Subject: Geologic Hazards Evaluation and Preliminary Geotechnical Investigation
Response to El Paso County Review Comments
Grandview Reserve, Phase 1, Filing 1
Eastonville Road and U.S. Highway 24
Falcon, Colorado
CTL|T Project No. CS19345-115

This letter presents our response to the El Paso County review comments dated May 9, 2023. CTL|Thompson, Inc. (CTL|T) prepared a Geologic Hazard Evaluation and Preliminary Geotechnical Investigation (CTL|T Project No. CS19345-115, dated May 9, 2022) for the proposed Grandview Reserve development located east of Eastonville Road and north of U.S. Highway 24 in El Paso County, Colorado.

**Groundwater
Conditions** Fig. 3

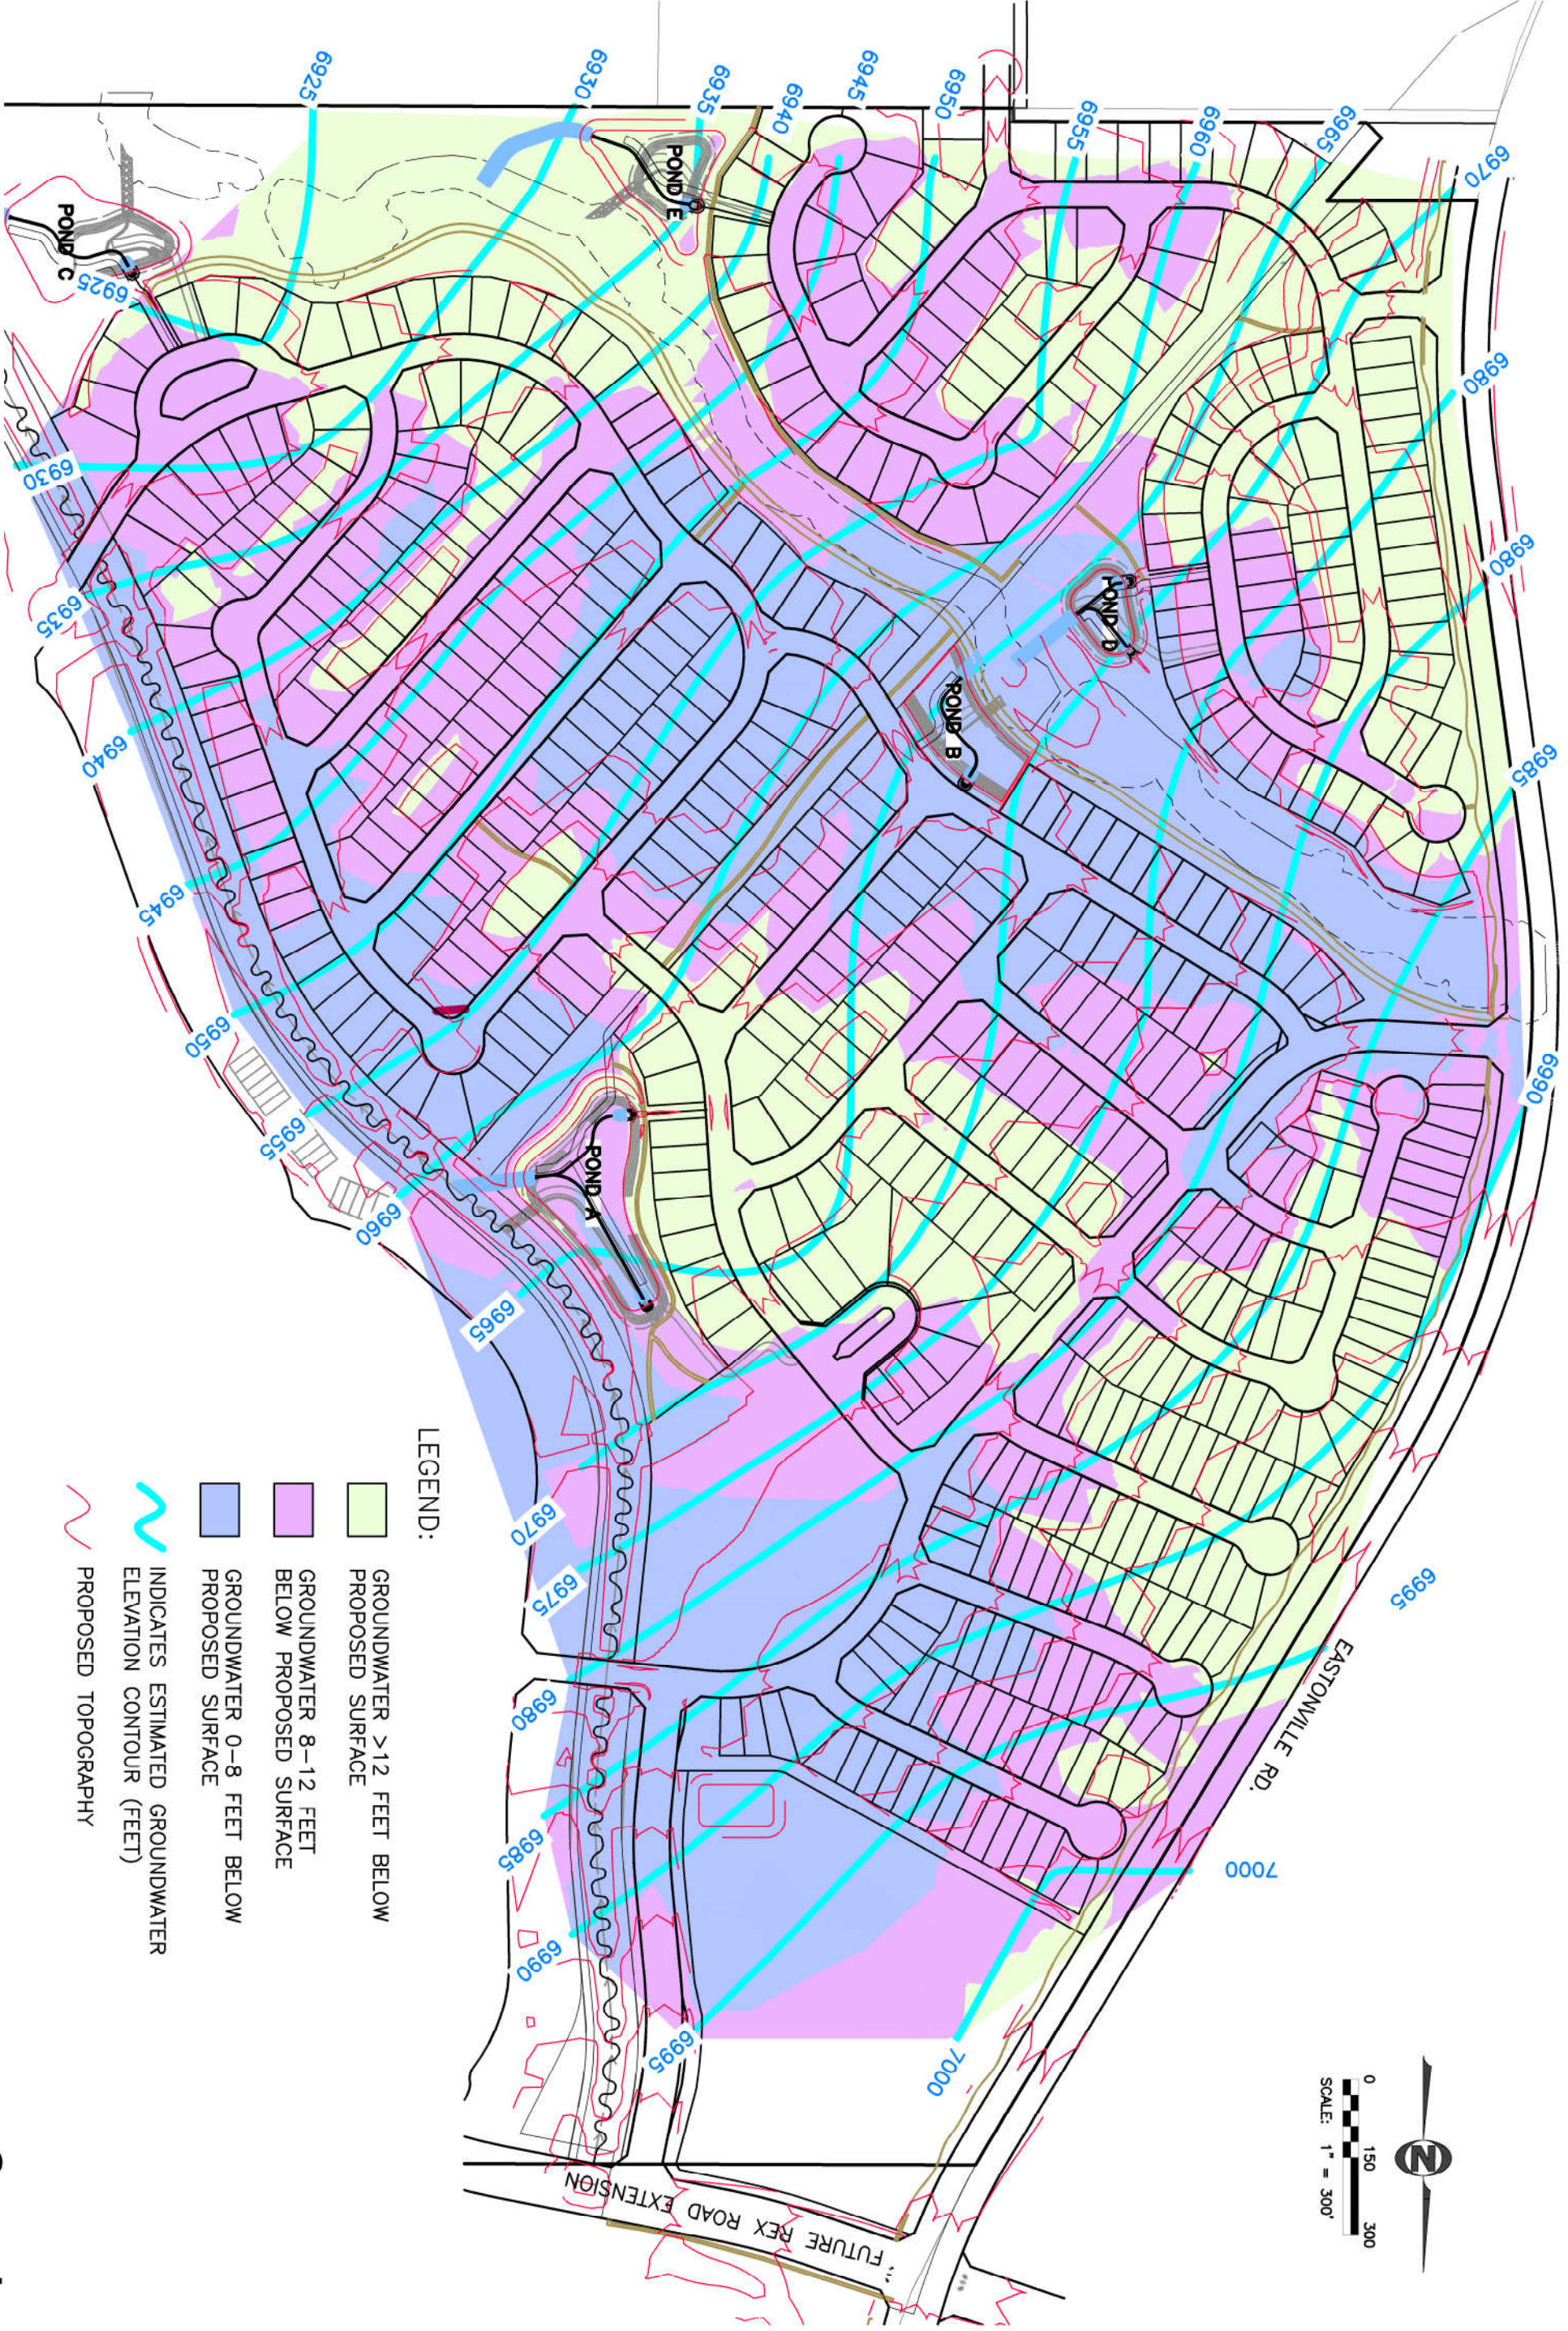
“A figure is missing depicting the various constraint and hazard mapping over the lot layout which was deferred from the prelimplan – see sample.” El Paso County requests that the subsurface conditions, site geology, and each of the geologic hazards including shallow groundwater, hard bedrock, expansive soils, flooding, seismicity, erosion, radon/radioactivity, and recoverable minerals be mapped, along with estimated heave potential.

An additional figure, titled Groundwater Conditions (Fig. 3), was included in our report that provided approximate groundwater elevation contours and heat mapping, that provides an

approximate depth to groundwater below the proposed finish grades. We also provided a figure titled Basement Construction Recommendations (Fig. 4), that depicted lots that are unsuitable for basement construction based on our groundwater data and analysis. We understand basement construction is not currently proposed. We have included a new figure attached with this letter, titled Surficial Geologic Conditions (Fig. 5), that delineates surficial geologic units across the site based on mapping and site reconnaissance. Considering the variability within the Dawson Formation, a detailed map of subsurface conditions beyond the surficial geology that is mapped in Fig. 5, cannot be produced. Additionally, the remaining geologic hazards presented in the report such as hard bedrock, seismicity, erosion, and radon/radioactivity cannot be mapped. These are generally regional hazards and it isn't possible to delineate the extents of each of the geologic hazards on every site. Attempting to do so would falsely suggest that these hazards may be possible in portions of the site and not possible in other portions of the site. A discussion of these hazards is provided in the referenced report.
